From: Amanda Scholes on behalf of Planning.Responses
Sent: 25 April 2018 07:59
To: Julie Grieves
Subject: FW: Further Information Required on Your Ref: PP-06871566 Our Ref: BR/100/18/HH
Attachments: 756 01 33 TENNYSON RD Block Plan REV A.pdf
Follow Up Flag: Follow up
Flag Status: Flagged

BR/100/18/HH

DWG NO	756/01	REV. A
--------	--------	--------

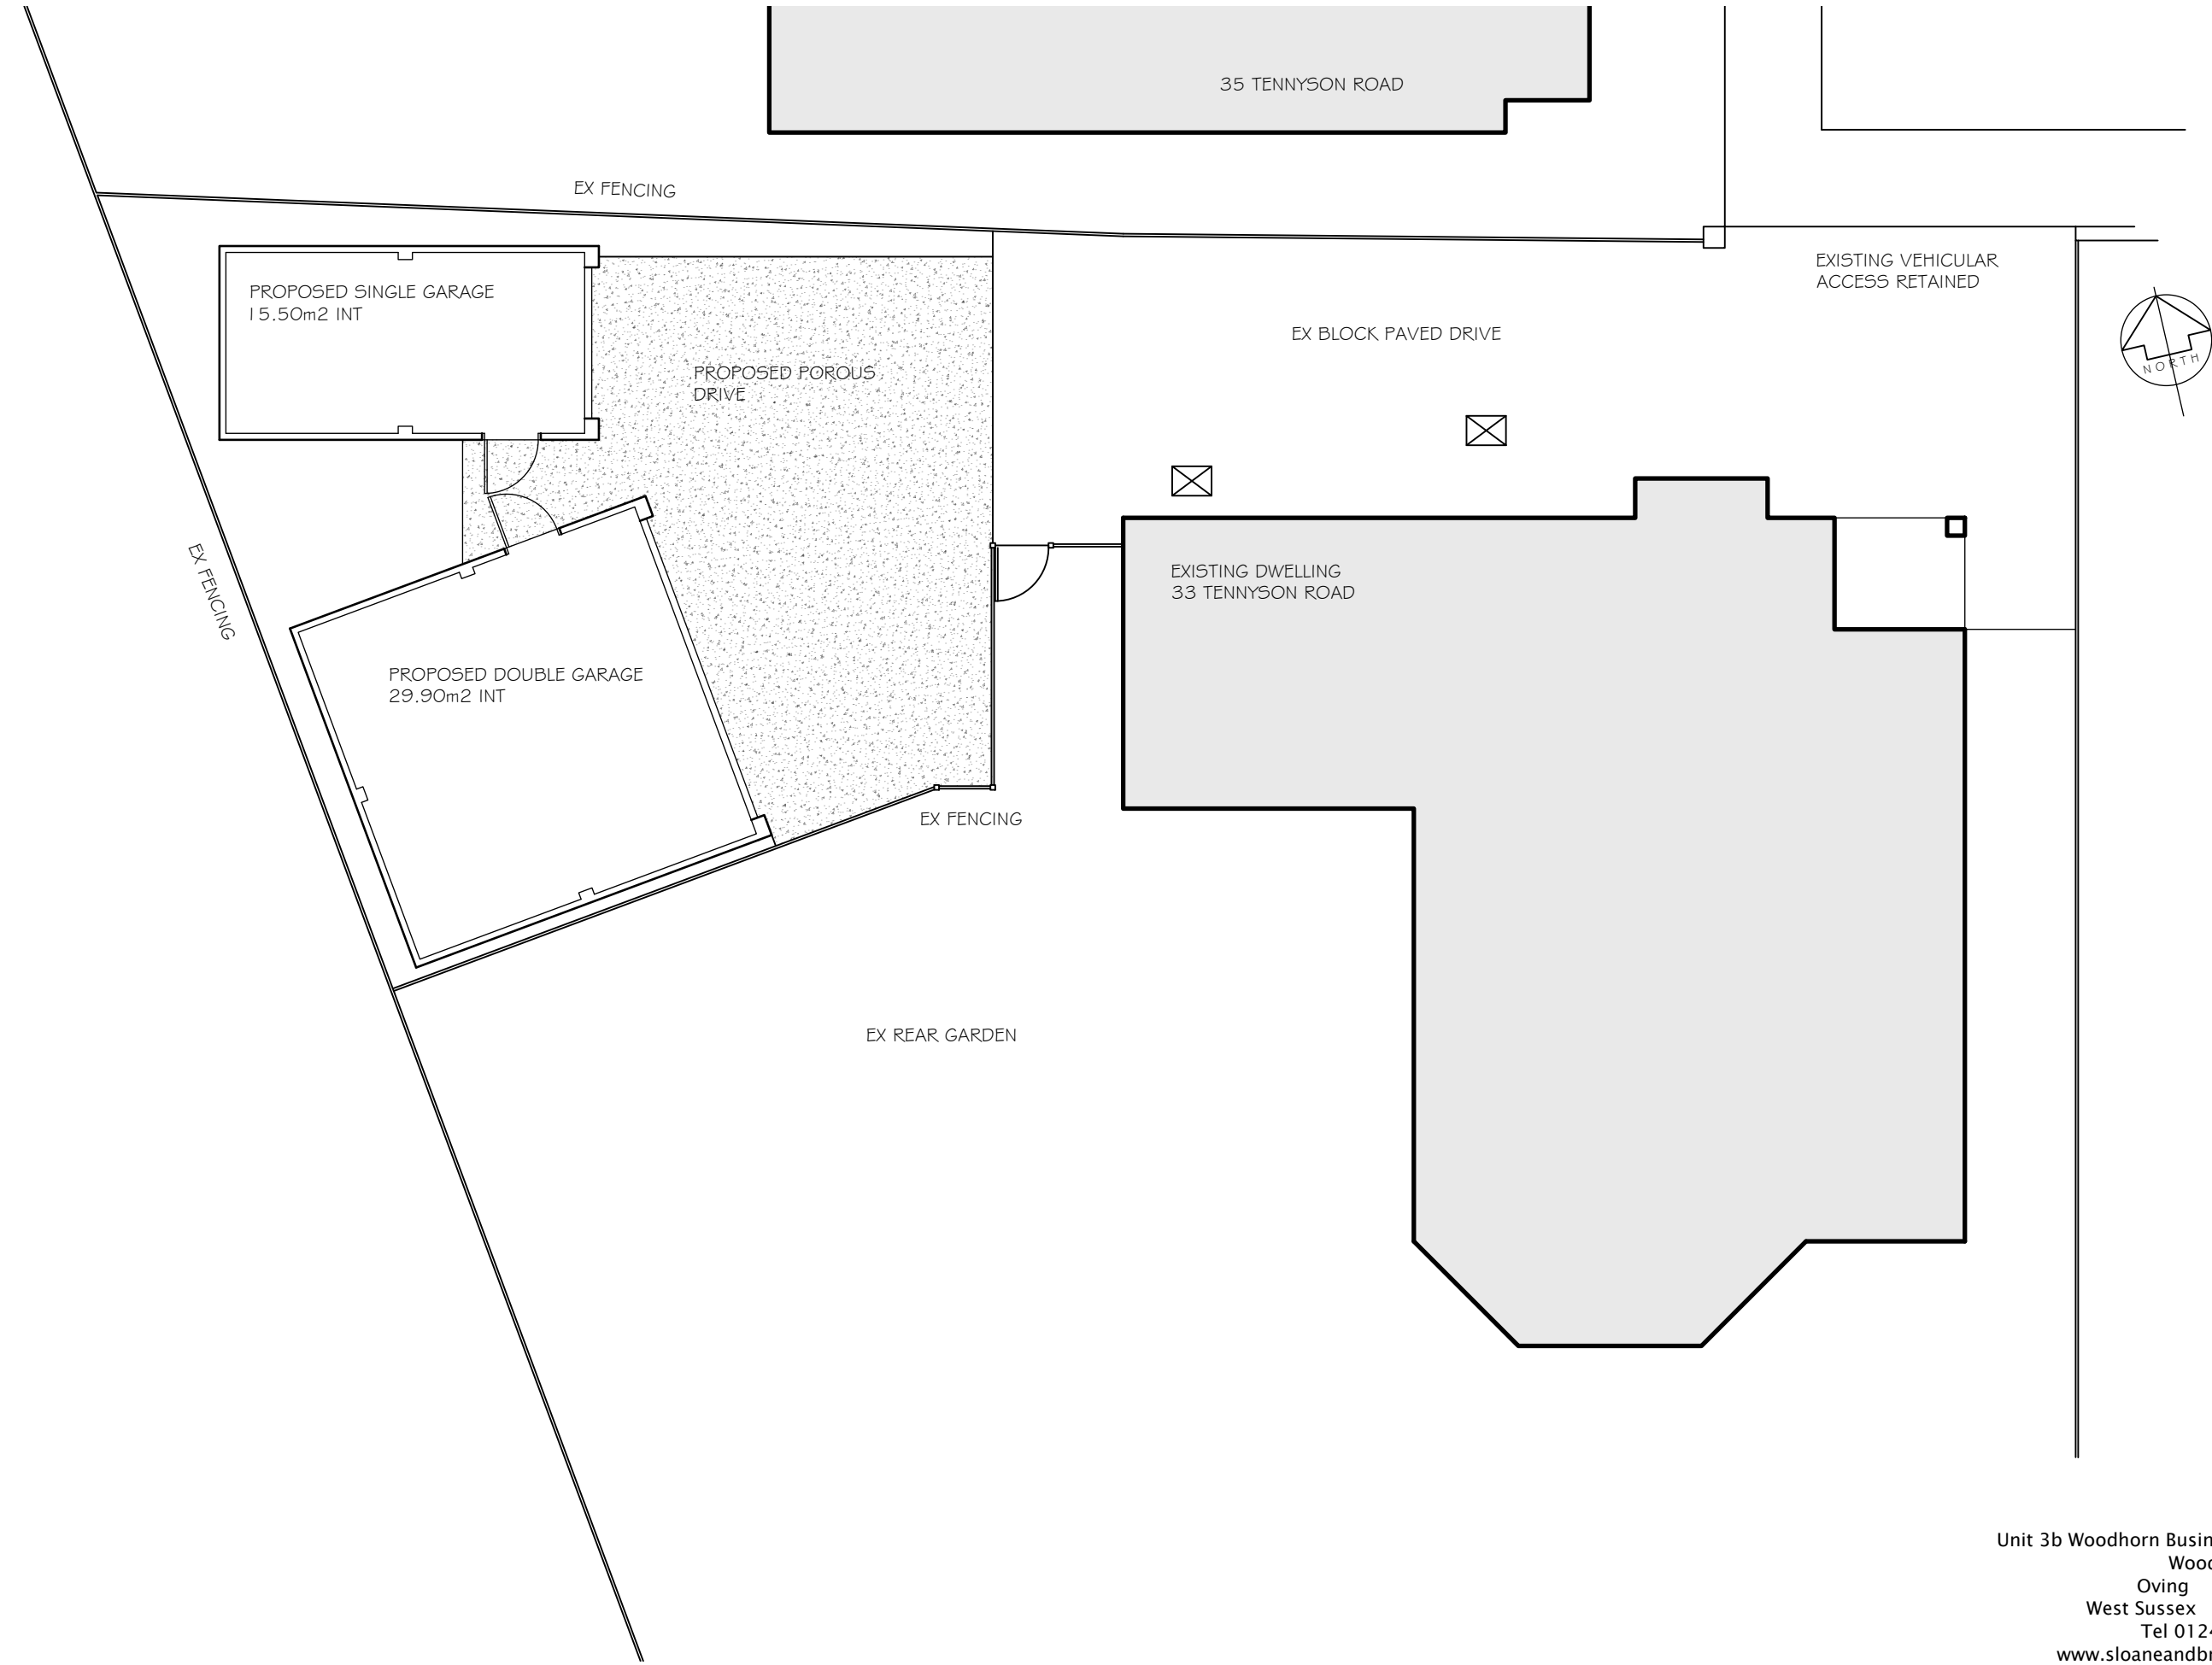
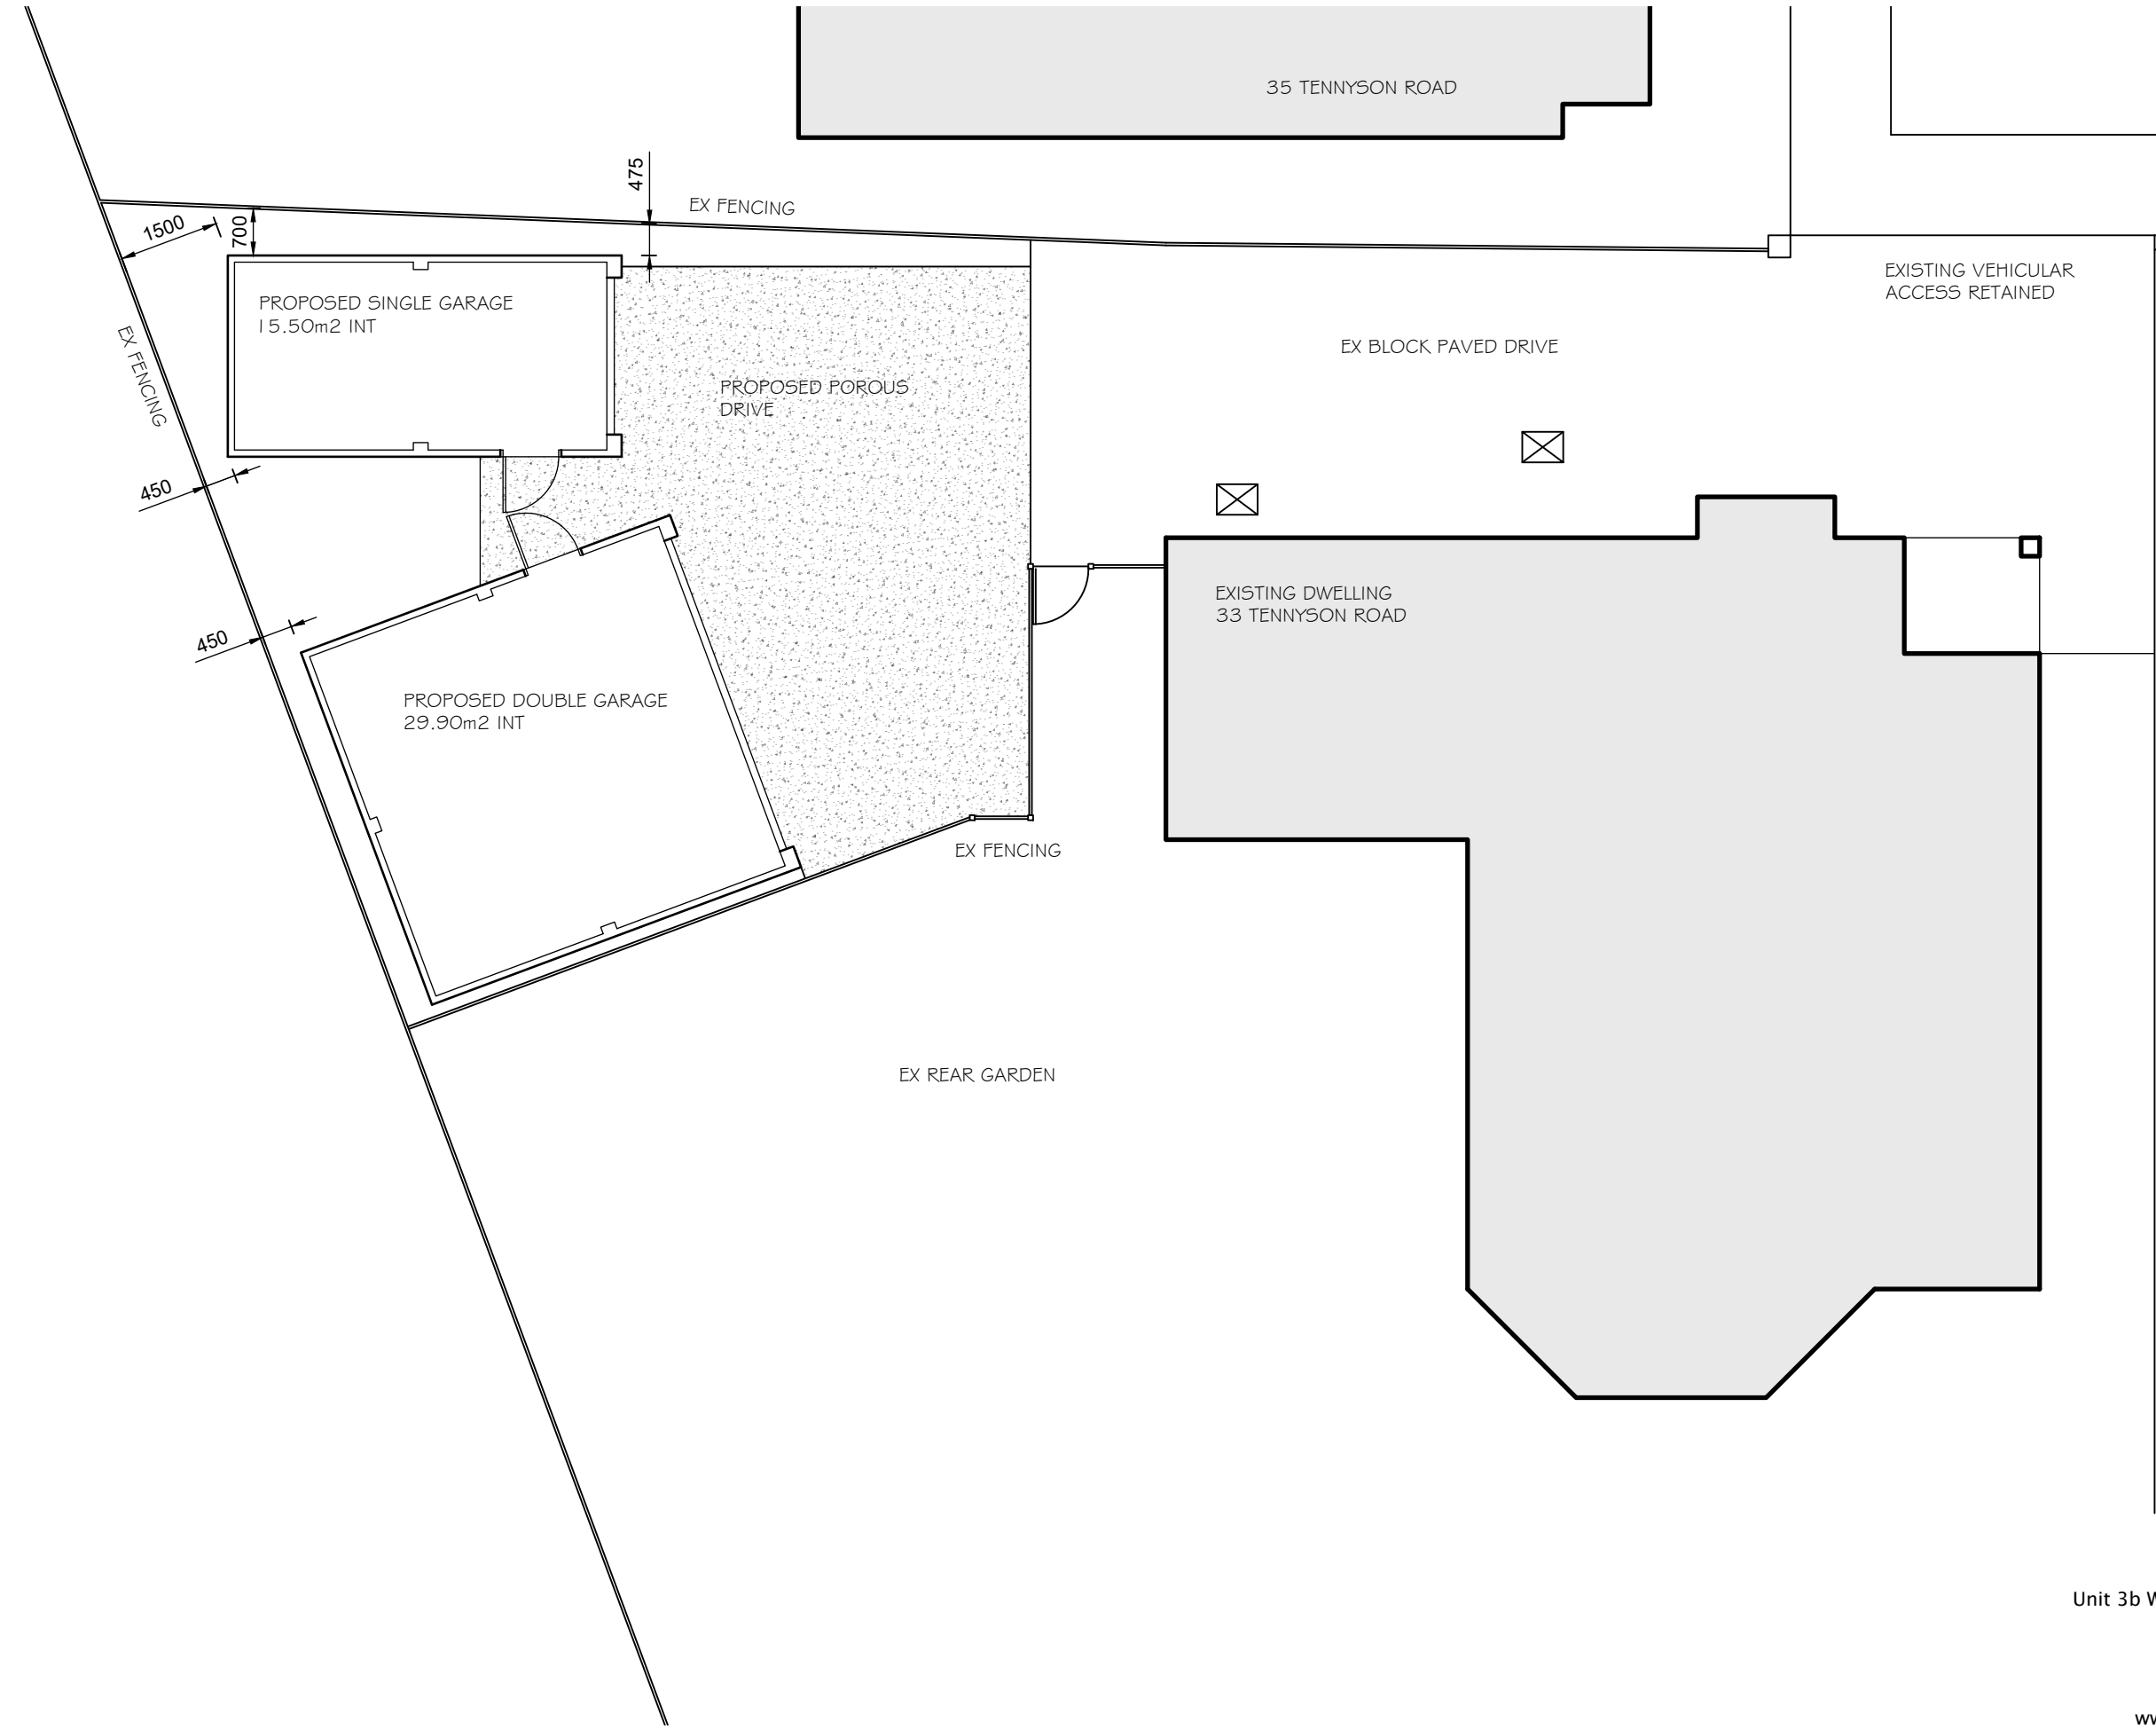
Please find attached the amended block plan as requested indicating dimensions to the boundaries from the proposed garages.
